Your Ref: 2023/91116
Our Ref: Z002461

15th March 2024

Land off Primrose Lane, Hightown, Liversedge - Erection of 77 dwellings, with access from Darley Road and associated works (Revised Description)

DRAINAGE STRATEGY

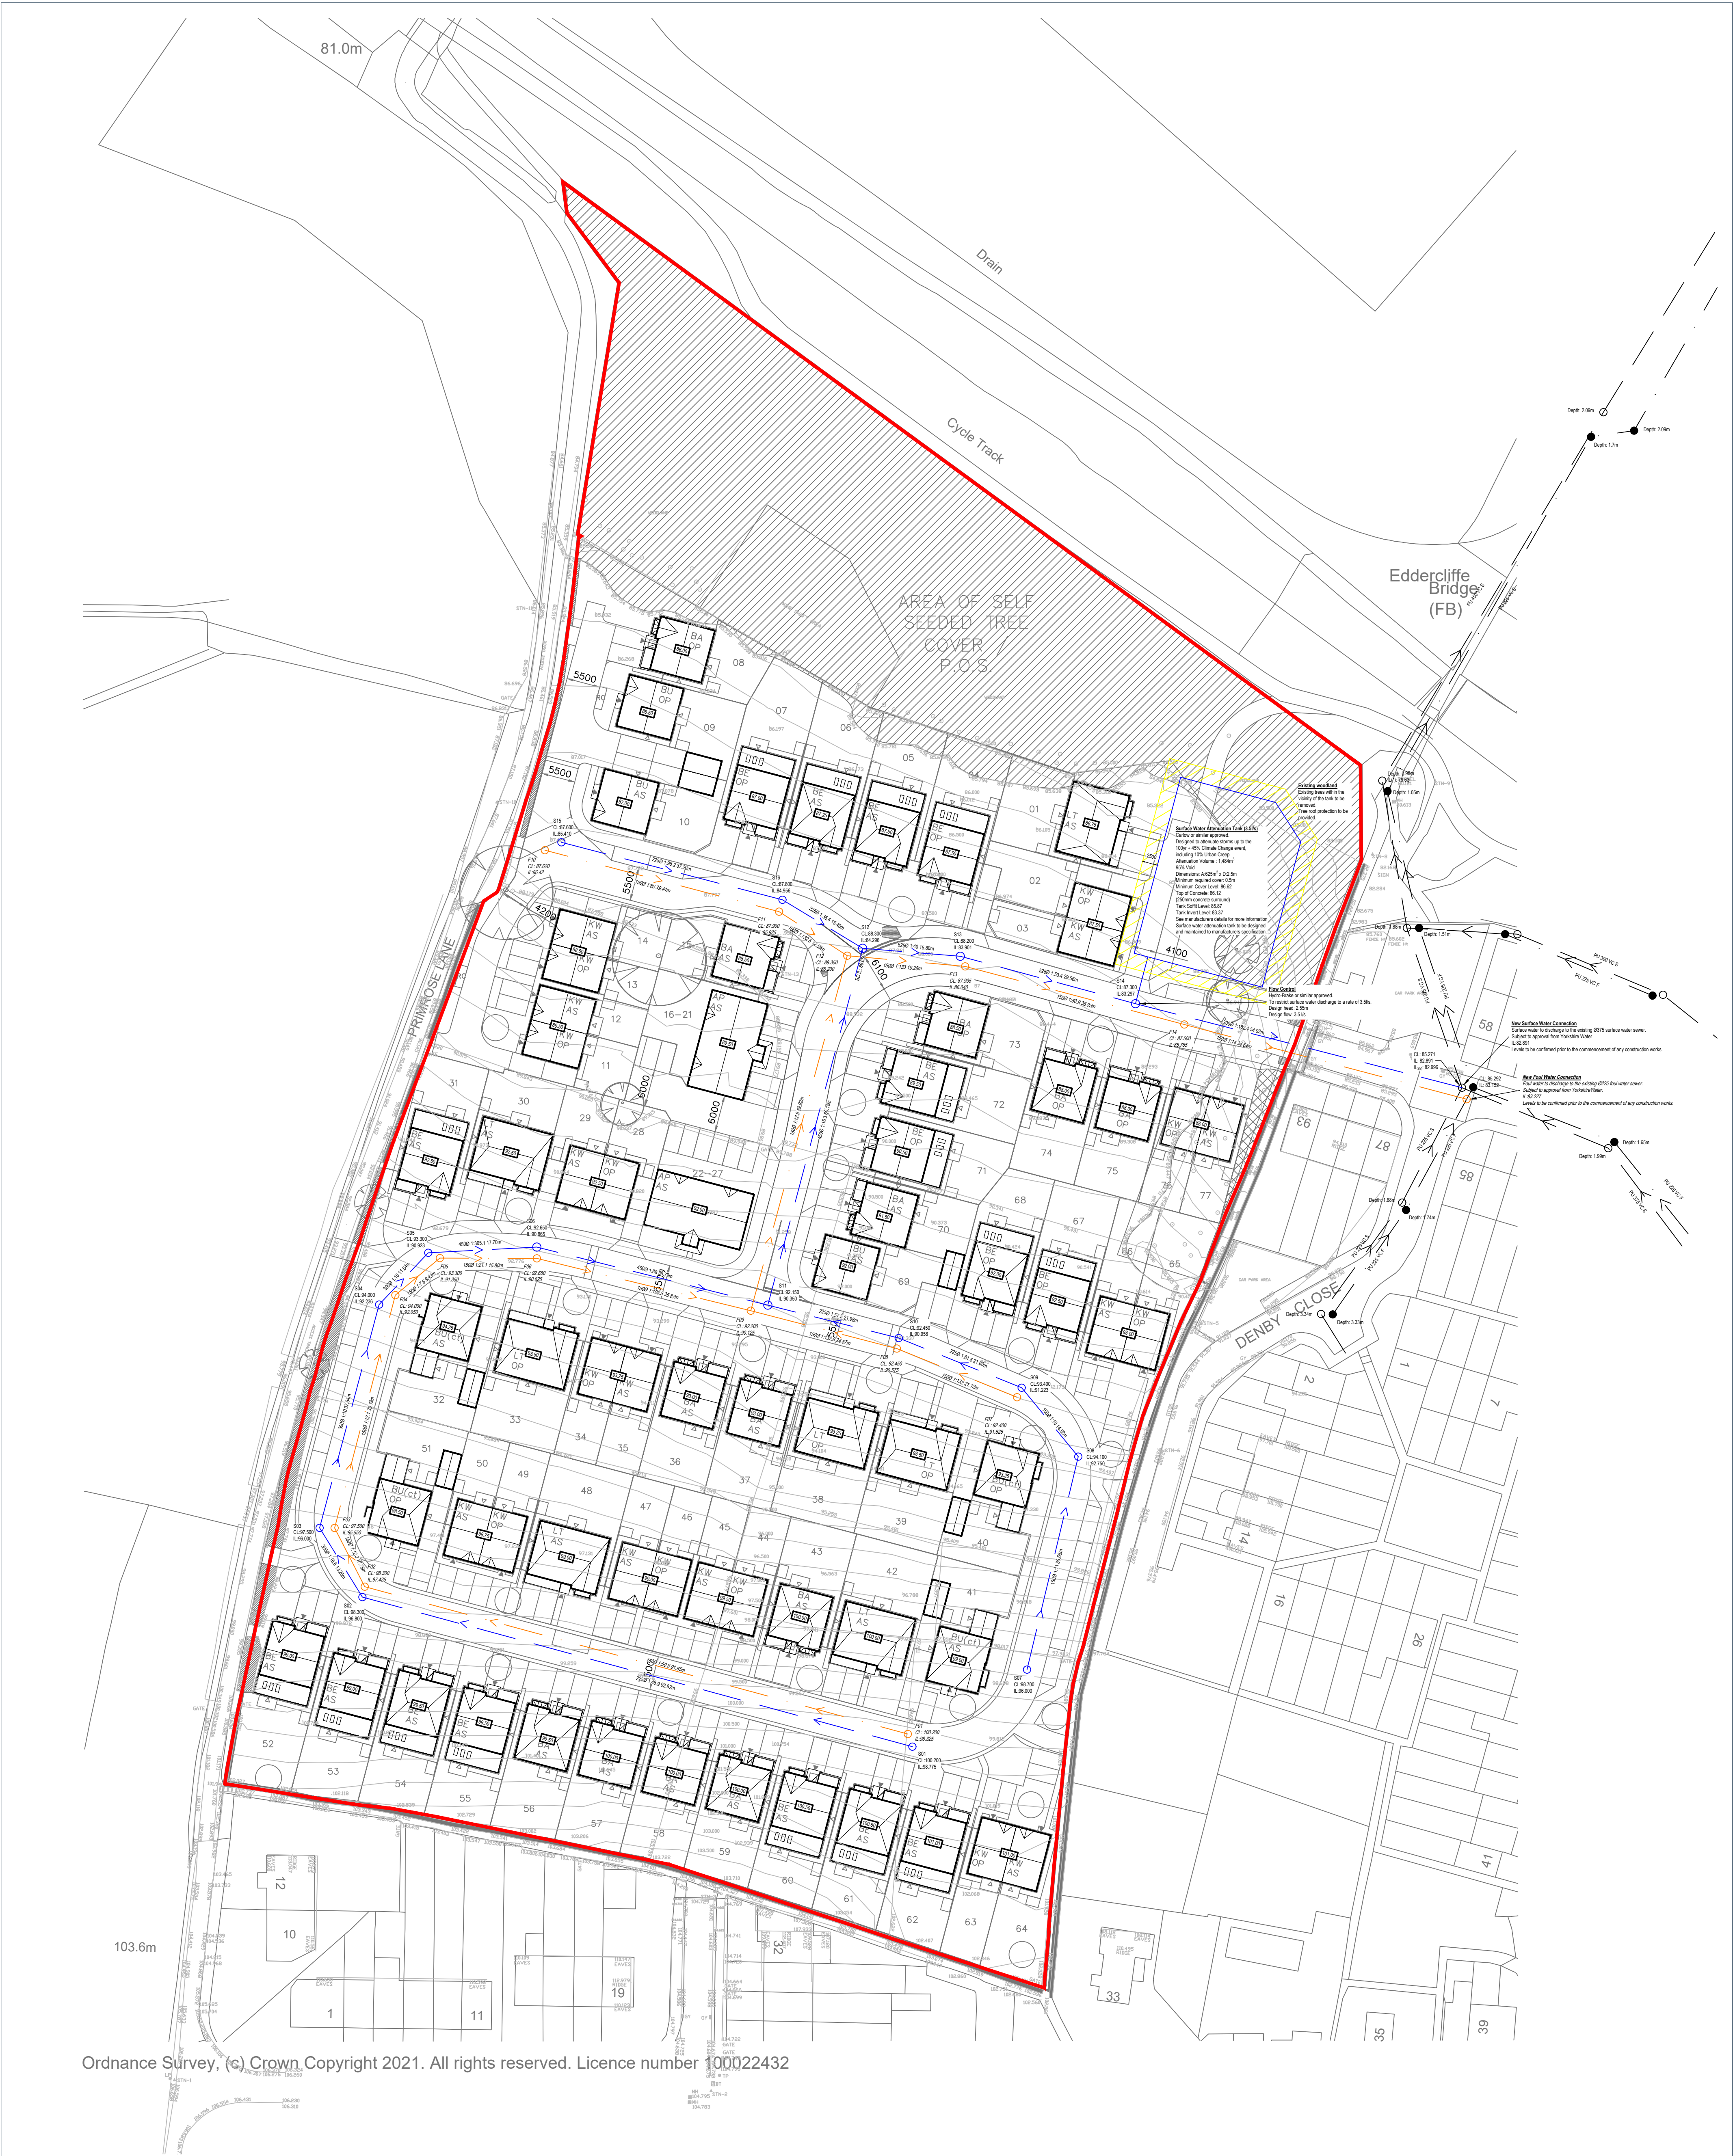
1.) The submitted 'Flood Risk Assessment' 47685 (issue 5) prepared by 05/01/21, dated 05/01/2024 requires amendments, but if planning permission is granted, the matter can be dealt with via condition.

The means of surface water management has not been properly considered within the FRA/drainage report. Yorkshire Water requires further information regarding the means of draining surface water from the development

2.) The developer is proposing to discharge surface water to public sewer however, sustainable development requires appropriate surface water disposal.

a.) Yorkshire Water promote the surface water disposal hierarchy and the developer must provide evidence to demonstrate that surface water disposal via watercourse are not reasonably practical before considering disposal to public sewer.

c.) As the proposal site is currently undeveloped, no positive surface water is known to have previously discharged to the public sewer network. Surface water discharge to the existing public sewer network must only be as a last resort and the developer is required to eliminate other means of surface water disposal.

d.) As a last resort, and upon receipt of satisfactory evidence to confirm the reasons for rejection of other methods of surface water disposal, curtilage surface water may discharge to public surface water sewer at a restricted rate of discharge not to exceed 3.5 litres per second.

PRIMROSE LANE
 PROPOSED SITE LAYOUT

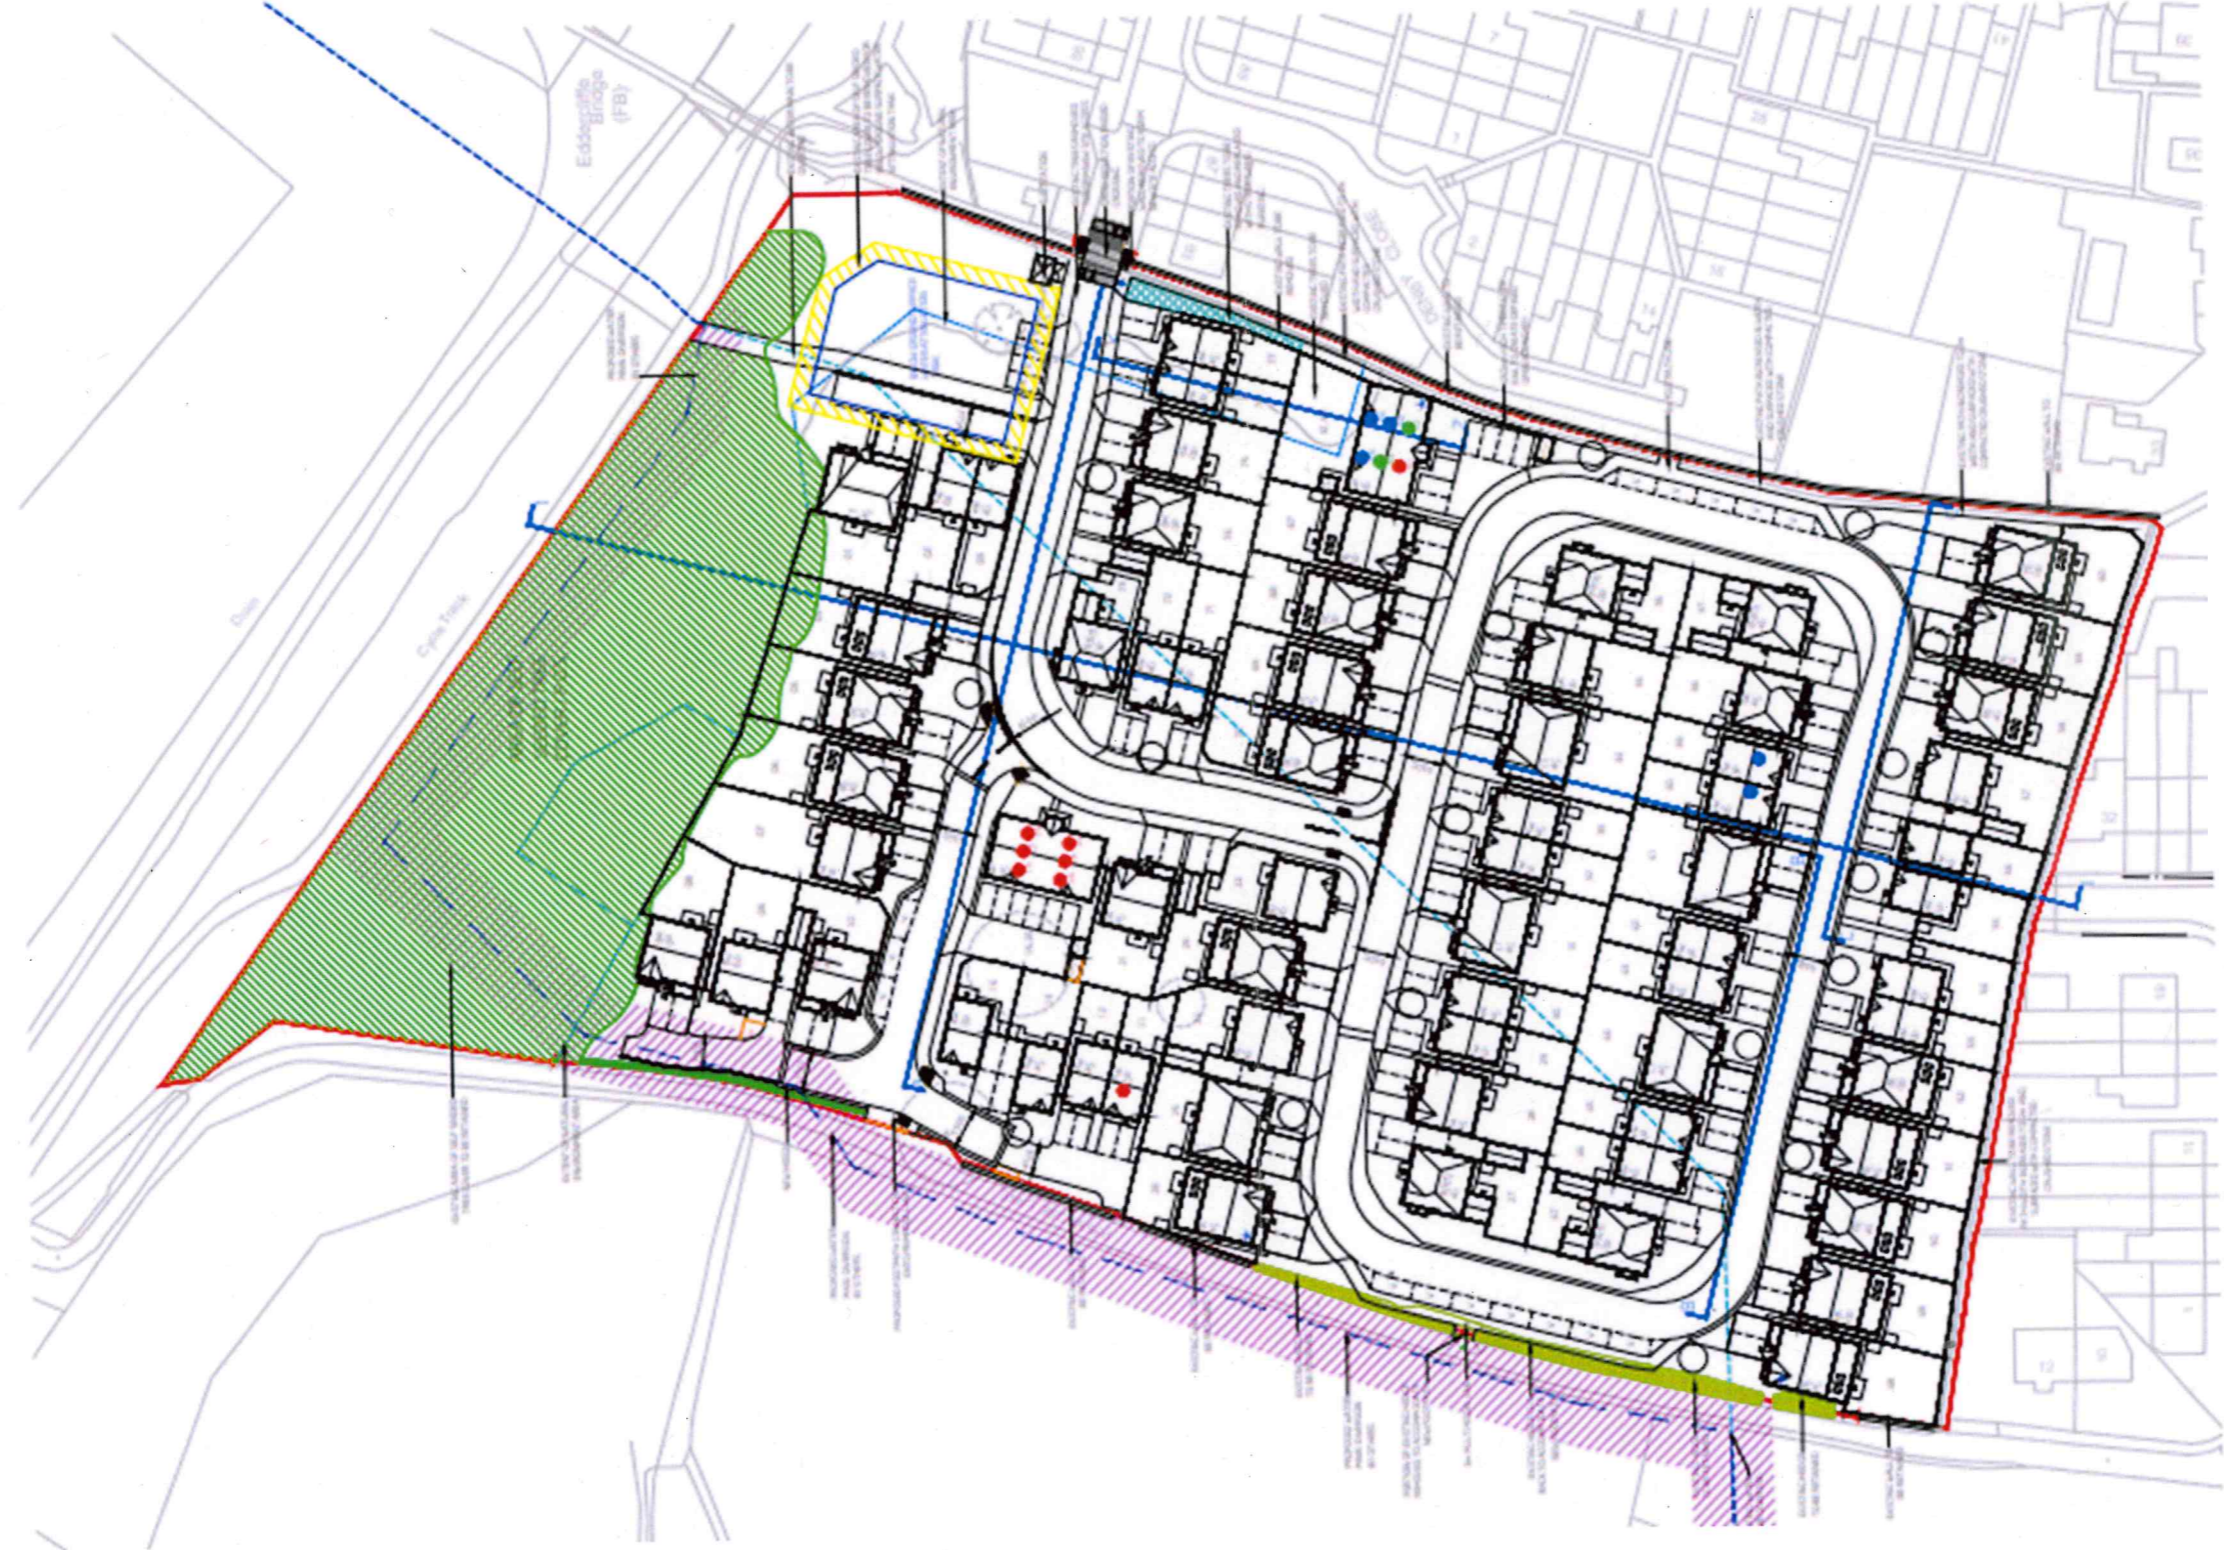
1.) The proposed site layout shown on drawing 'Proposed Site Layout' 3416-1-001 (Rev Ee) dated 01/03/24, as prepared by Niemen, shows an acceptable design diversion for the on-site water main water main, to be completed through a section 185 diversion application.

2.) On the Statutory Sewer Water main map, there is a 700mm diameter ductile Iron water main recorded to cross the site. It is essential that the presence of this infrastructure is taken into account in the design of the scheme.

a.) In this instance, a legal easement of 12 metres (6 metres either side) is required at each side of the sewer centre-line and it may not be acceptable to raise or lower ground levels over the sewer, nor to restrict access to the main.

c.) There should be no new tree planting within 6 metres of the public sewer.
